Rezoning Transportation Analysis
Petition Number: Insert Zoning Petition #2021-263
General Location Identifier: 15717222, 15717233

Revision Log:	Date	Revision Log:
	04-18-2022	First Review (WB)

The site is located at the northeast quadrant of the intersection of two City-maintained local streets, Colwick Road and Chiswick Road. A Traffic Technical Memorandum (TTM) is necessary for the complete review of this petition due to ingress and egress concerns that are triggered by the site's proximity to a highly congested thoroughfare on the high injury network. A Draft study was submitted to CDOT on 3/29/2022 and is currently under review.

RZ1-0

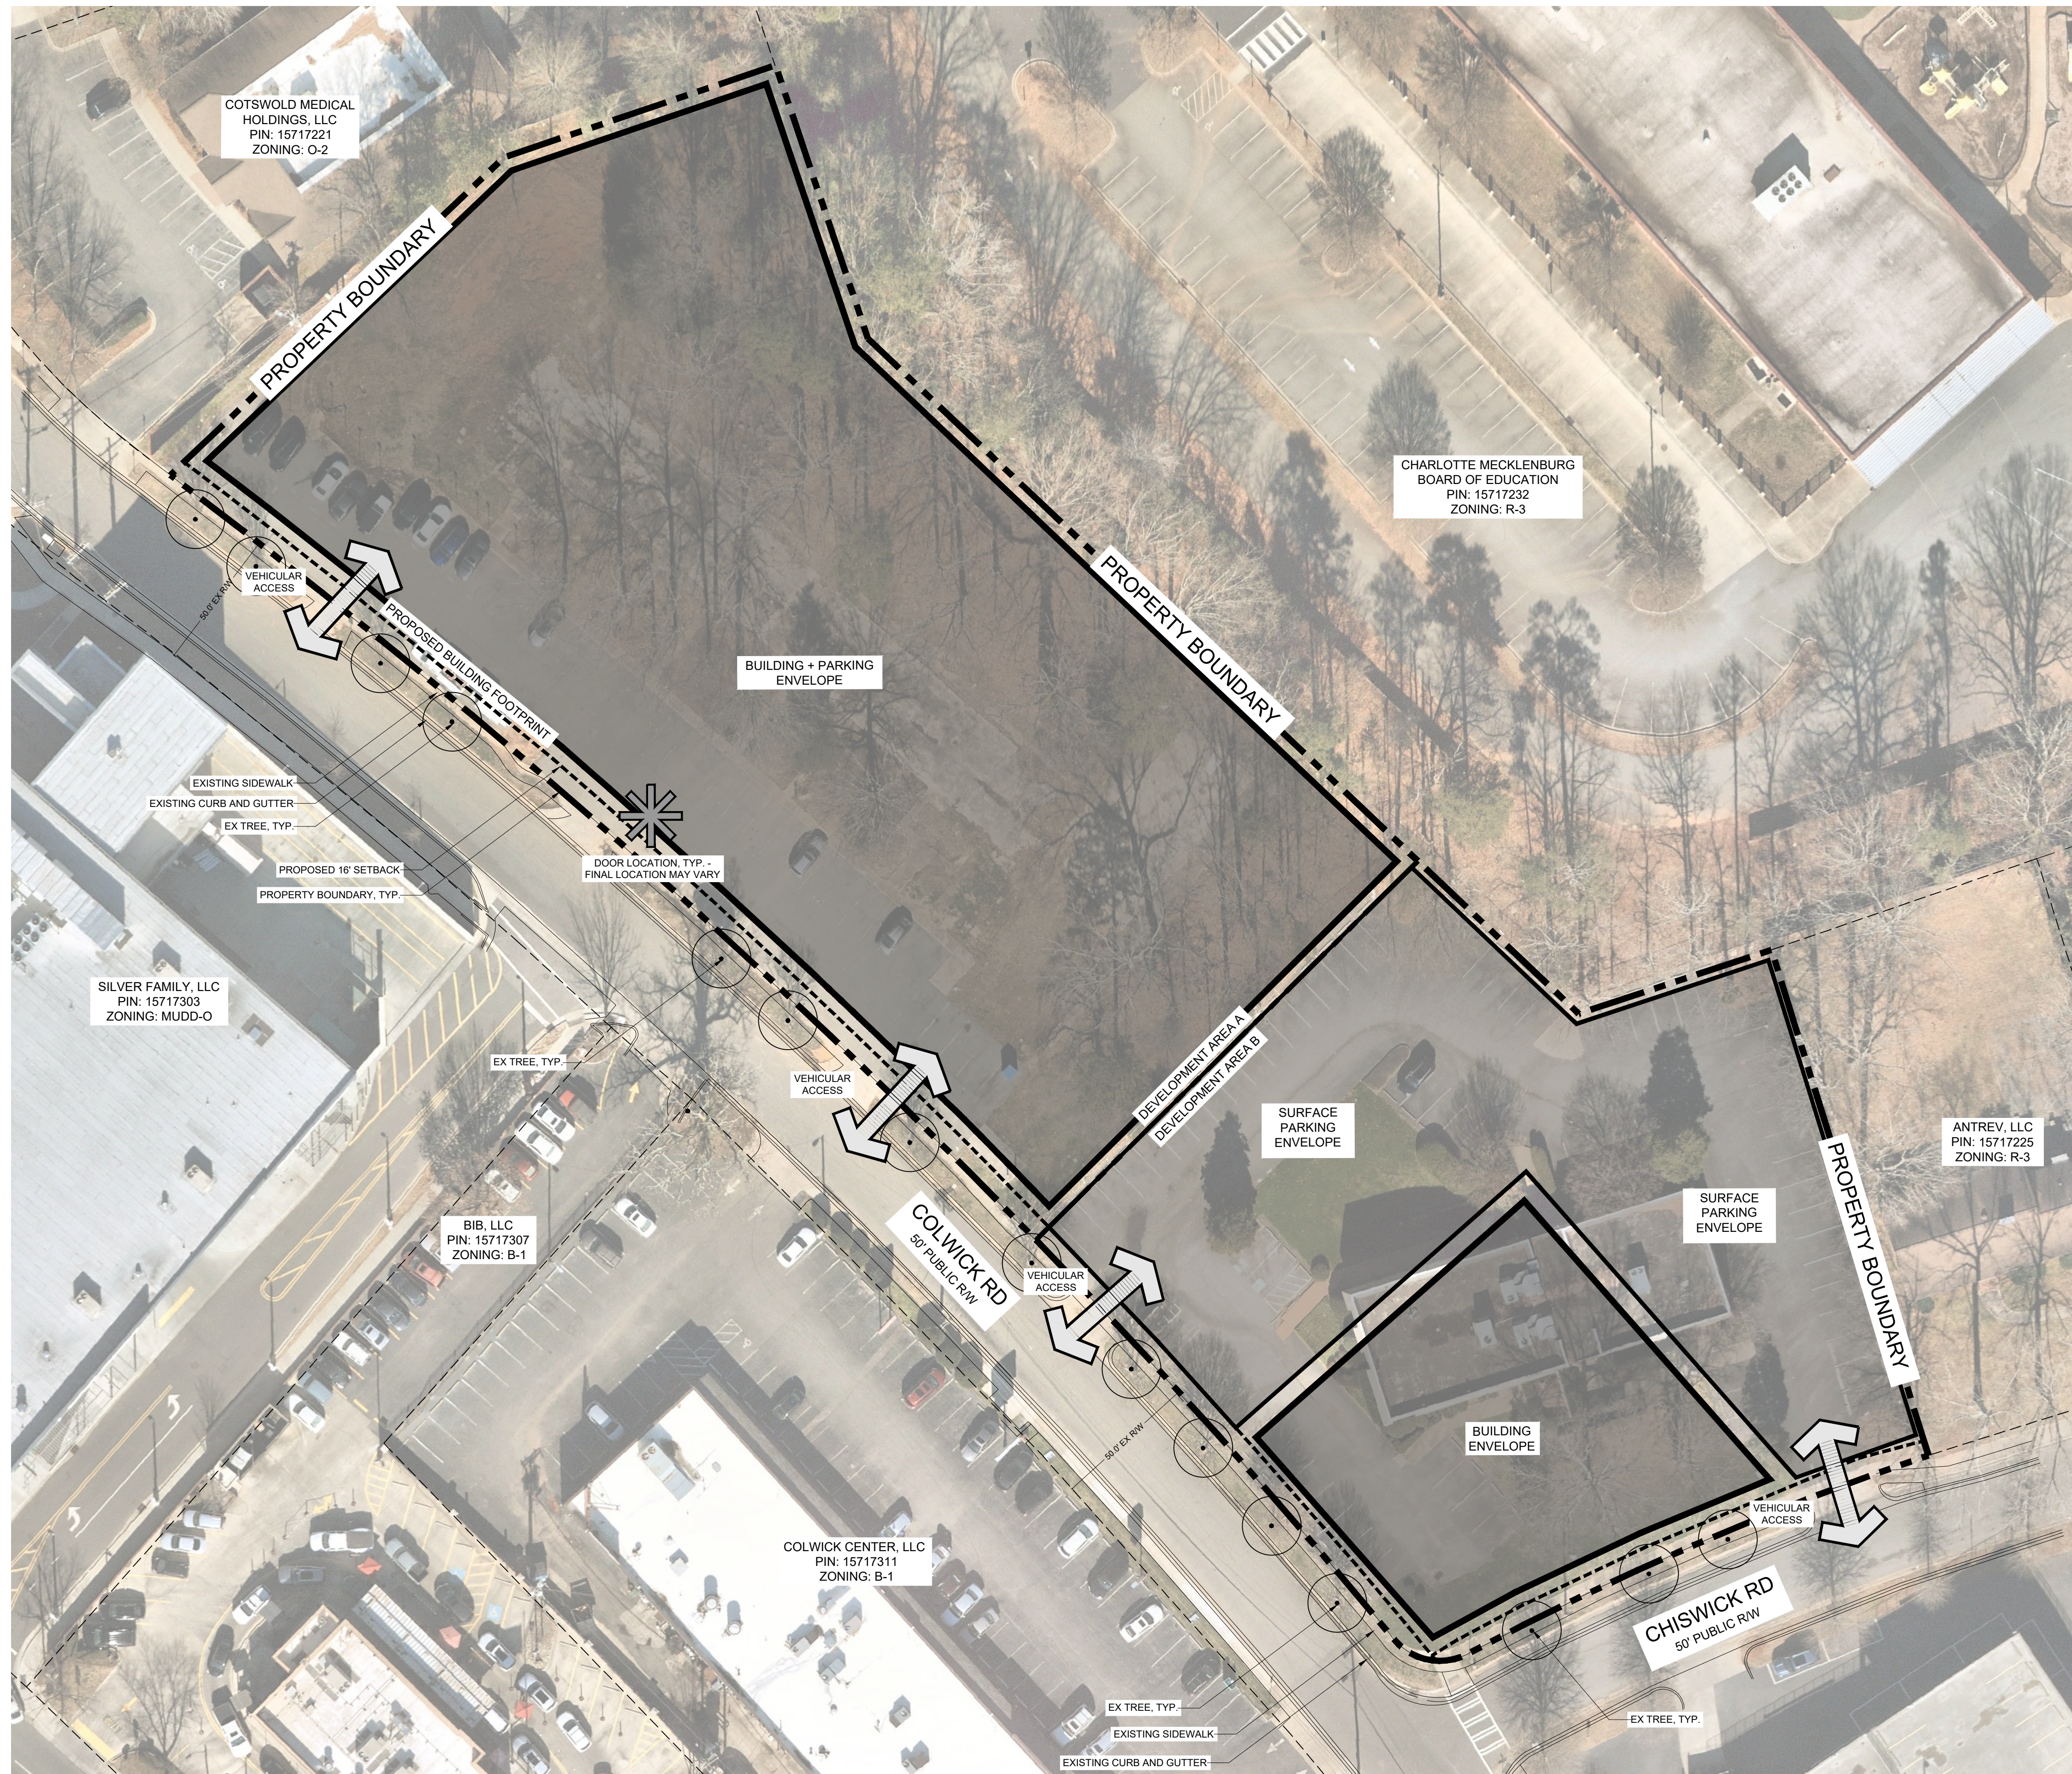
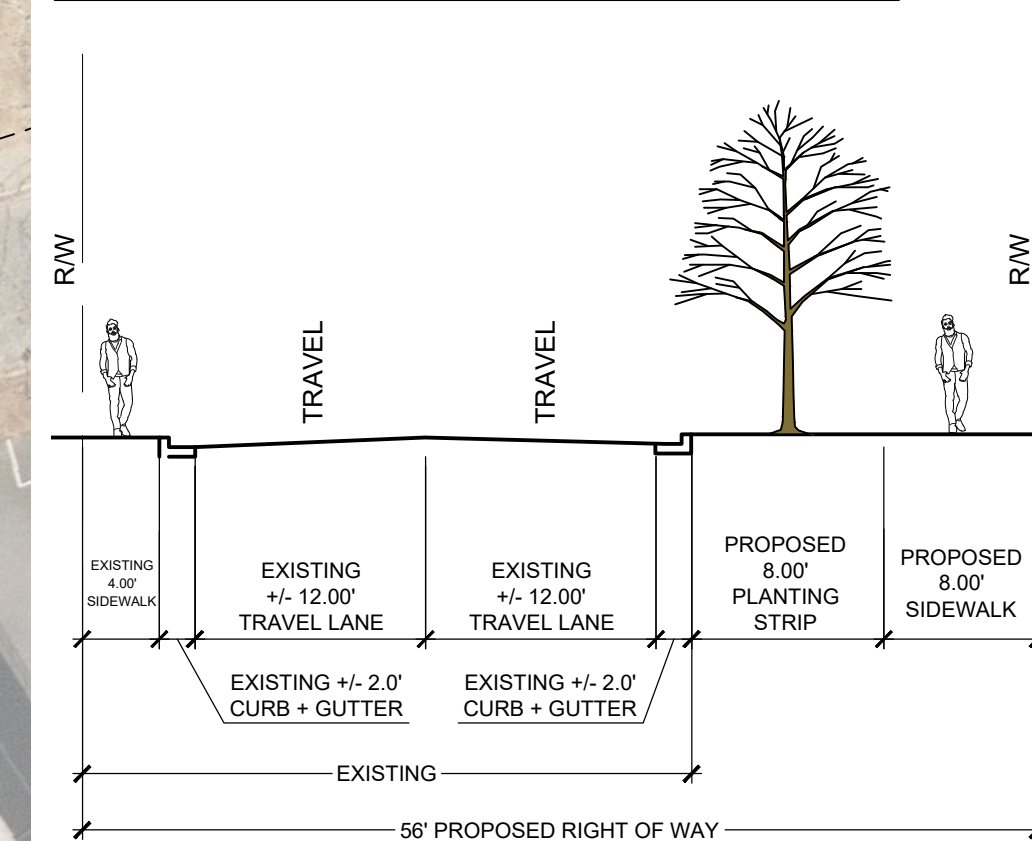
1. **Curblines:** The proposed zoning district has a setback measured from the back of the existing or proposed future curblines.
 - a. **Colwick Road:** The back of curb and gutter needs to be relocated to 20.5-feet from the road centerline.
 - b. **Chiswick Road:** The back of curb and gutter needs to be relocated to 20.5-feet from the road centerline.

Label and dimension the curb and gutter from the centerline for each road on the site plan.

2. Revise site plan and conditional notes to commit to dedicate 28.5-ft (minimum) right-of-way from the road centerline of both Public streets per Chapter 20 of the City's ordinance. The site plan shall label and dimension the right-of-way from the road centerline.

3. Revise site plan and conditional notes to commit to reconstruct the curb and gutter 20.5-ft from the road centerline of both Public streets to provide on-street parking per the Local Commercial Wide typical section and Chapter 20 of the City's ordinance. The site plan shall label and dimension the proposed back of curb and gutter from the road centerline.

4. Revise site plan and conditional notes to commit to construct an 8-foot planting strip, and 8-foot sidewalk on Chiswick Road per Chapter 20. The site plan shall label and dimension both items from the back of curb and gutter and road centerline. The wider sidewalk also meets the Charlotte WALKS Policy.
